**SSD7720; Dubbo Base Hospital Redevelopment Stage 4; Golden Highway (HW27); Dubbo
Environmental Impact Statement**

Thank you for your email on 3 April 2017 referring the development application and *Environmental Impact Statement* for Stage 4 of the Dubbo Hospital Redevelopment to Roads and Maritime Services for comment.

PROPOSED CARPARKING & ROUNDABOUT PLANS  
(SUBJECT TO FINAL LAYOUT AS REQUIRED)

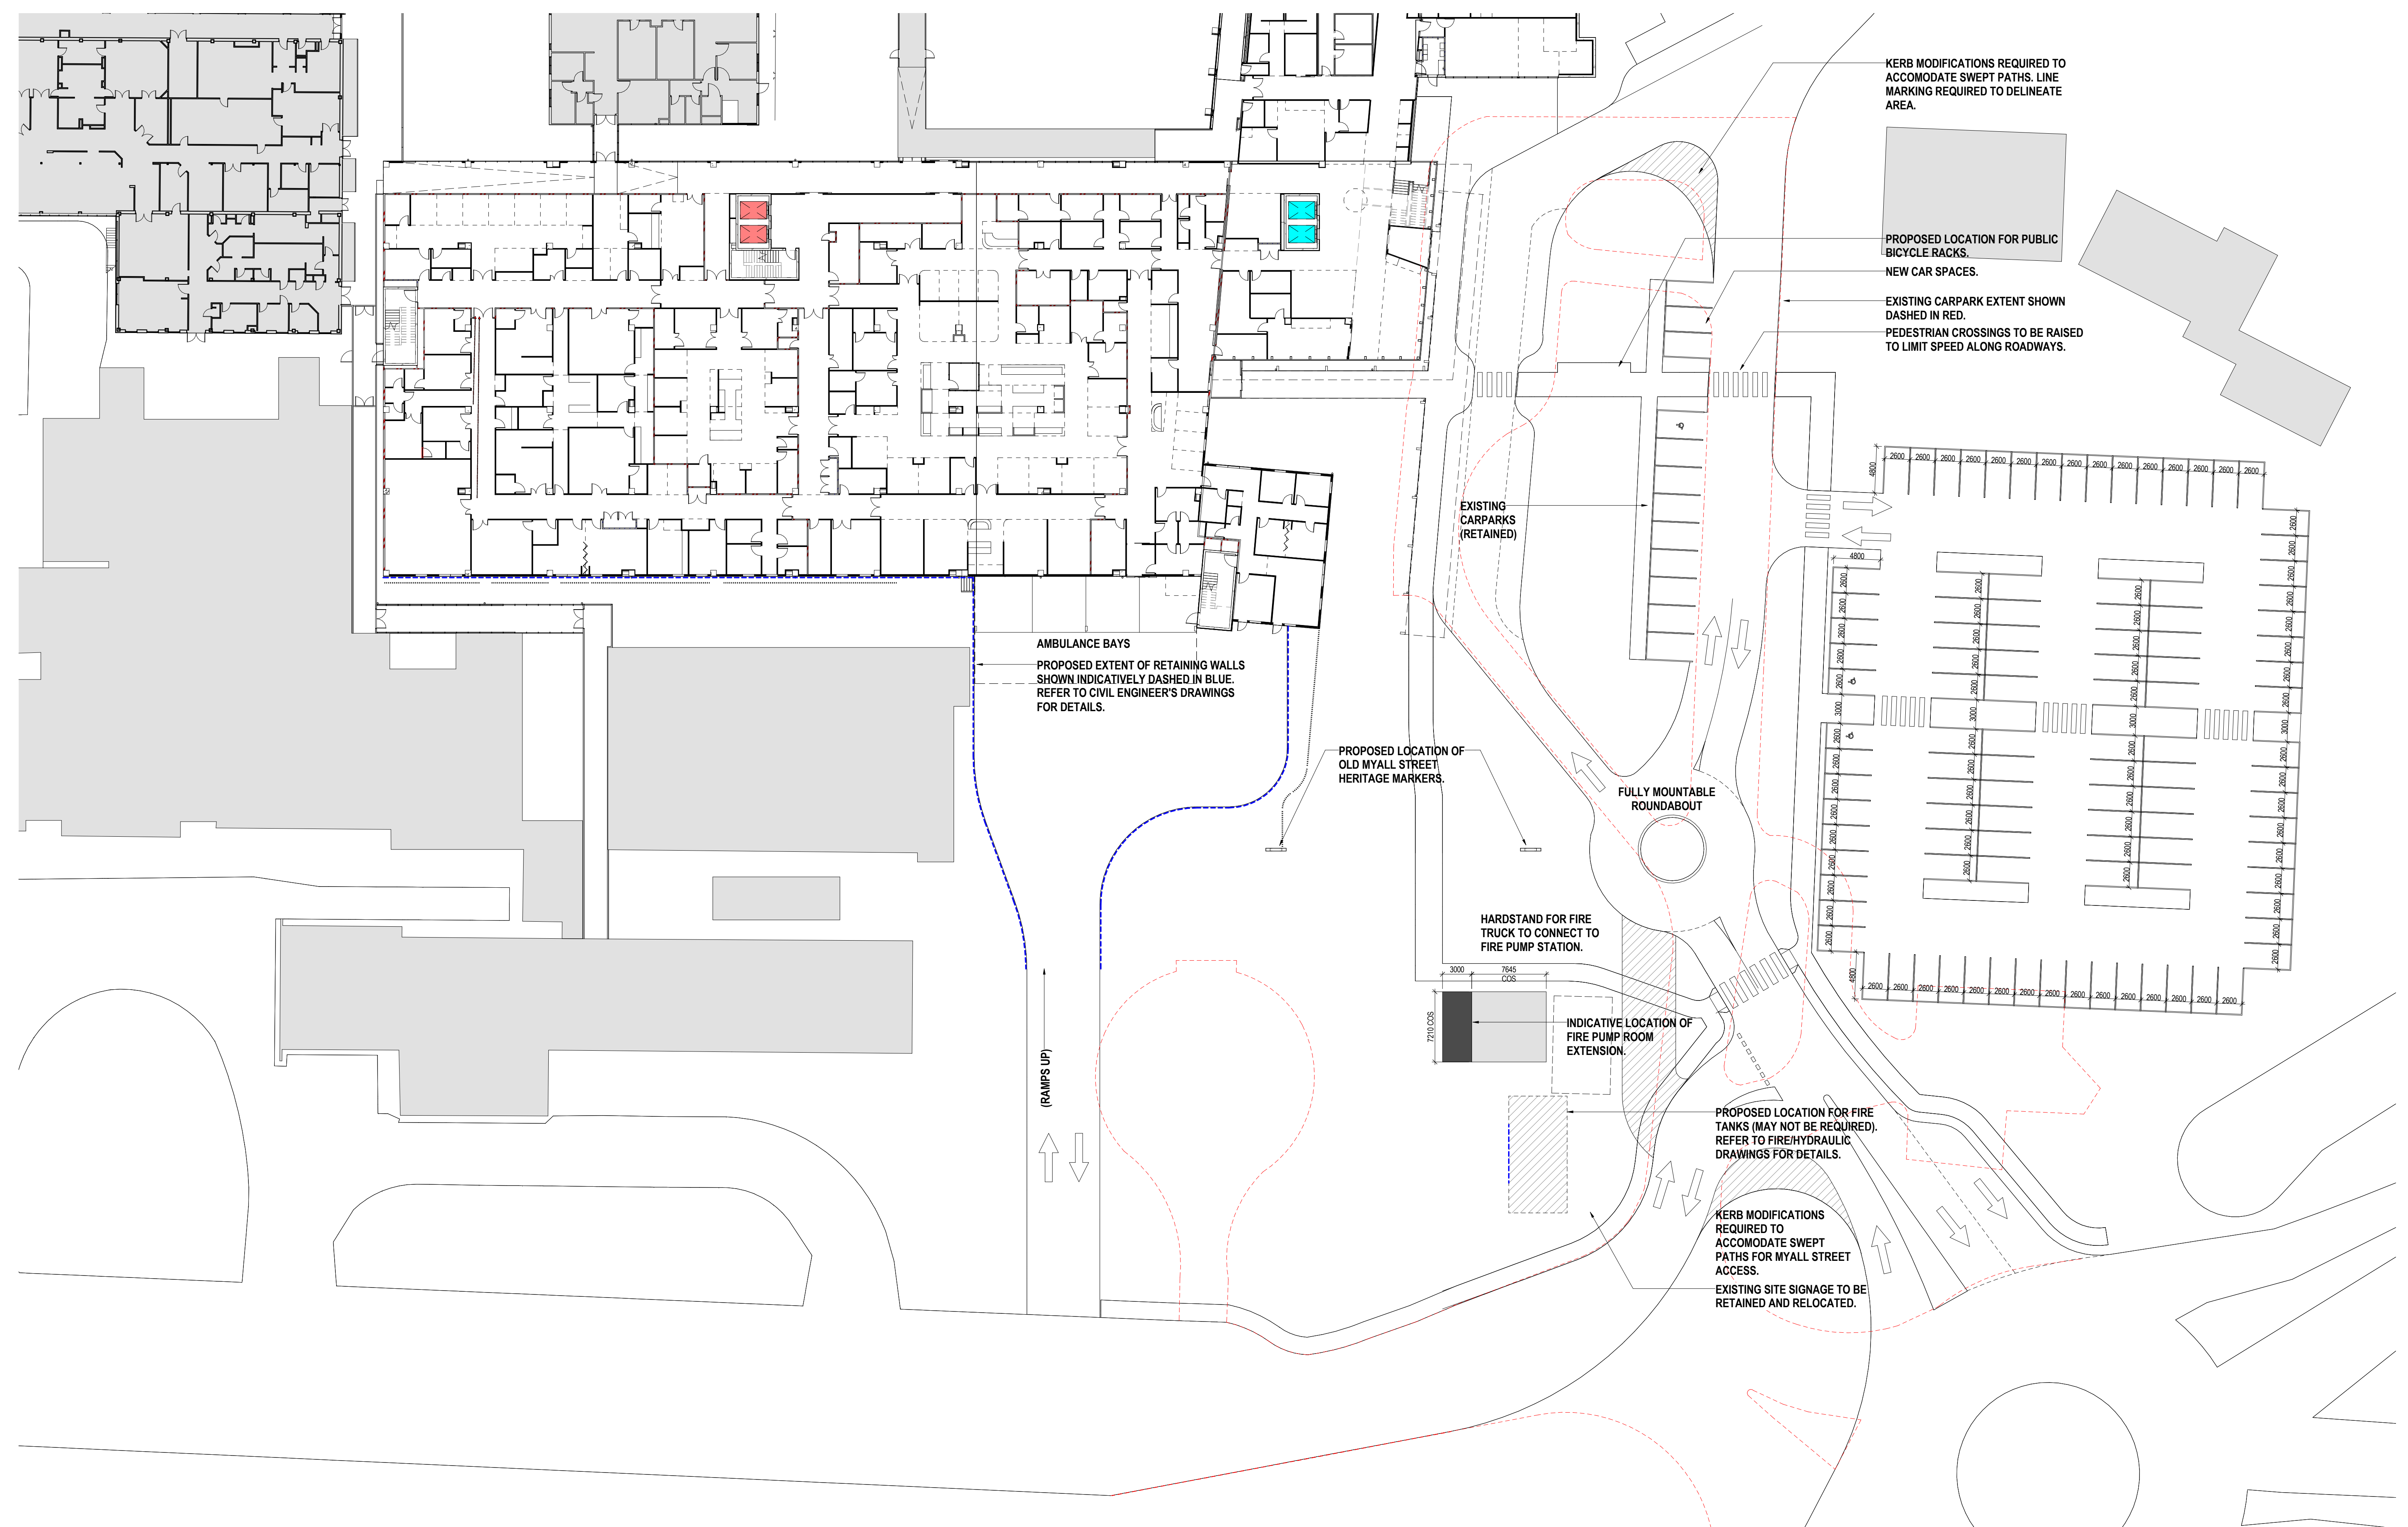
The submitted plans and documentation do not appear to provide the full level of parking required to meet peak demands and to avoid road safety issues with drivers parking in uncontrolled areas such as road shoulders. In particular:

- Section 4.1.3 states that 131 car spaces are required to meet patient related demand, however, section 4.1.1 states that only 104 spaces will be provided.
- Section 4.1.2 states that 118 parking spaces are needed to accommodate for an increase in staff. This appears to show that, at a minimum, 249 total spaces are required.
- No consideration appears to be given to providing adequate parking during peak times, such as staff changeover periods.
